Our ref: Wentworth Avenue Multi-level Warehouse (SSD-73846459)

Subject: Wentworth Avenue Multi-level Warehouse (SSD-73846459) further information for the Response to Submissions Report

Attachment 1: The Department's comments on the EIS

Figure 22: Traffic Movements (Source: Nettletontribe Architects, 2024)

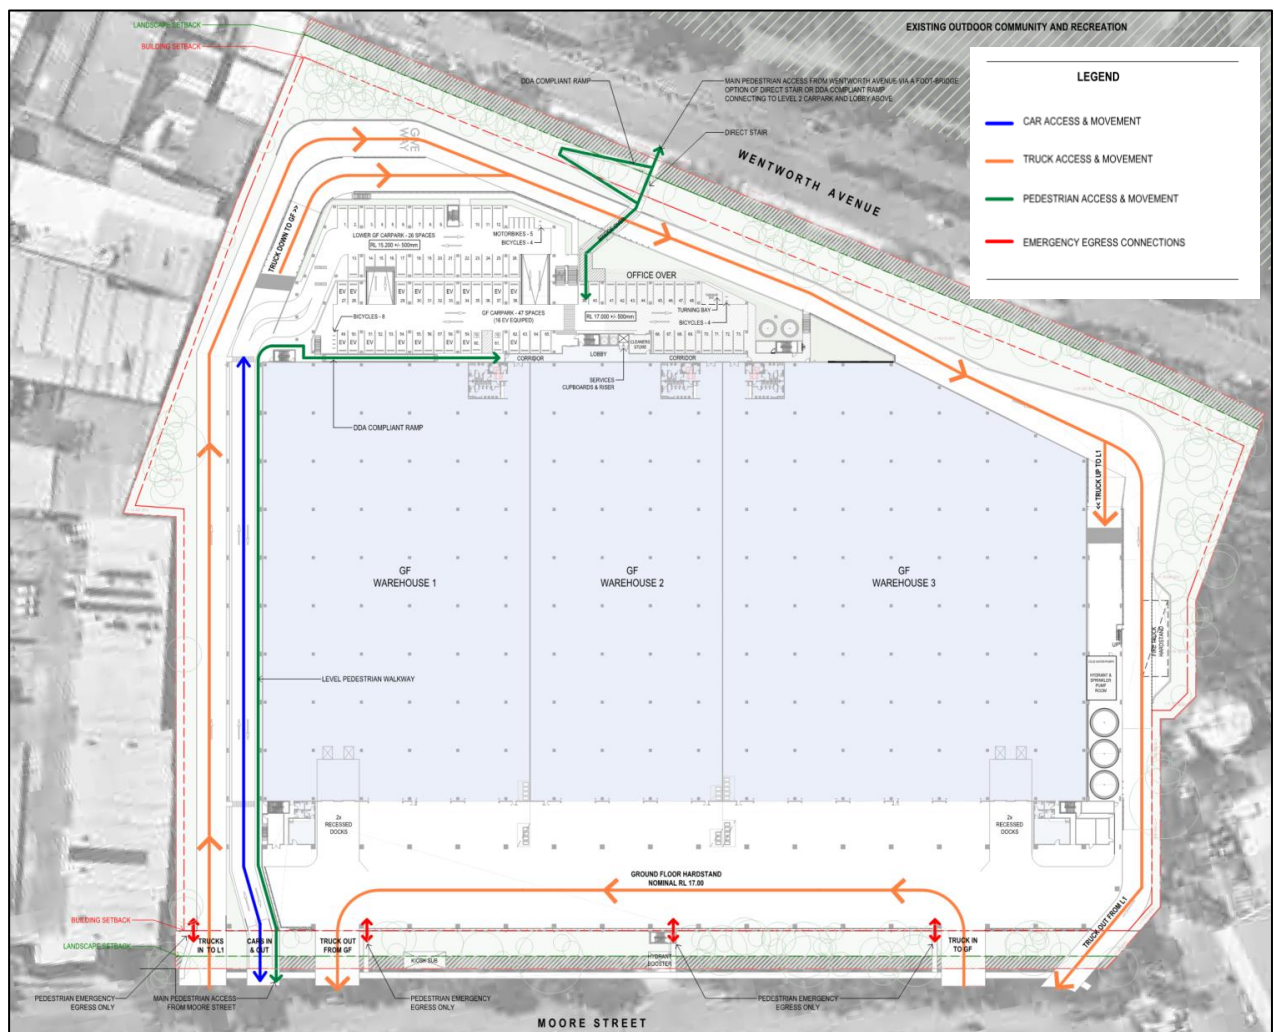
2. The Traffic Impact Assessment (TIA) identifies increased delays at the Wentworth Avenue/Baker Street signalised intersection as a result of the increase in vehicle movements in the AM and PM peaks. The Applicant is to address the anticipated impact of the development and list what traffic management options are to be implemented to minimise the impact.
3. Swept path analysis for the range of heavy vehicles entering the site via the proposed driveways needs to be revised to show that on-street parking on both sides of Moore Street are not impacted, with the vehicles being able to enter and exit without utilising the whole of Moore Street.

Figure 52: Noise Receivers (Source: Renzo Tonin, 2024)

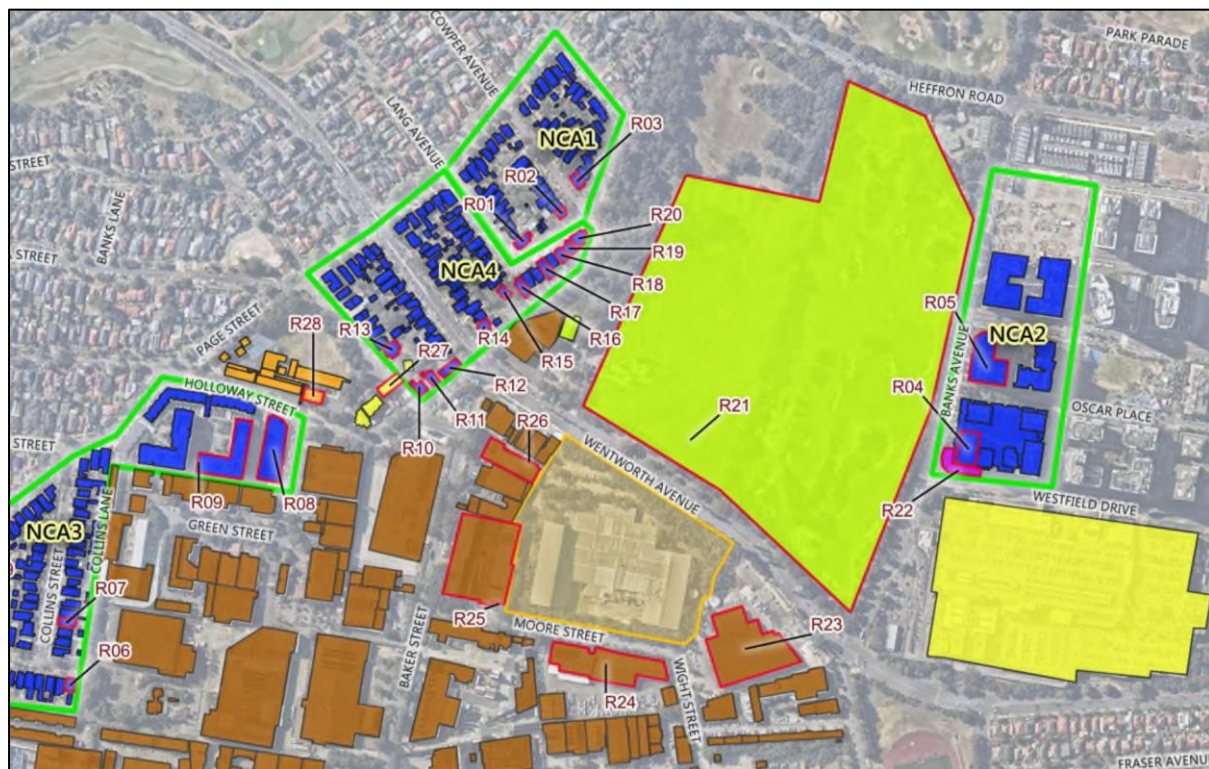
6. Unless otherwise justified, additional noise monitoring must be undertaken at the potentially most-affected residences identified with reference to the predicted operational noise contours. A statement justifying the selection of each monitoring site must be provided, including the procedure used to choose each site, to address requirements outlined in Fact

Sheets A and B of the Noise Policy for Industry. The justification must consider the definition of the “reasonably most affected location(s)”. For instance, noise monitoring location L2 at the courtyard balcony corner of 520/126 Banks Avenue does not appear to represent the potentially most-affected residences within 15 Oscar Place.
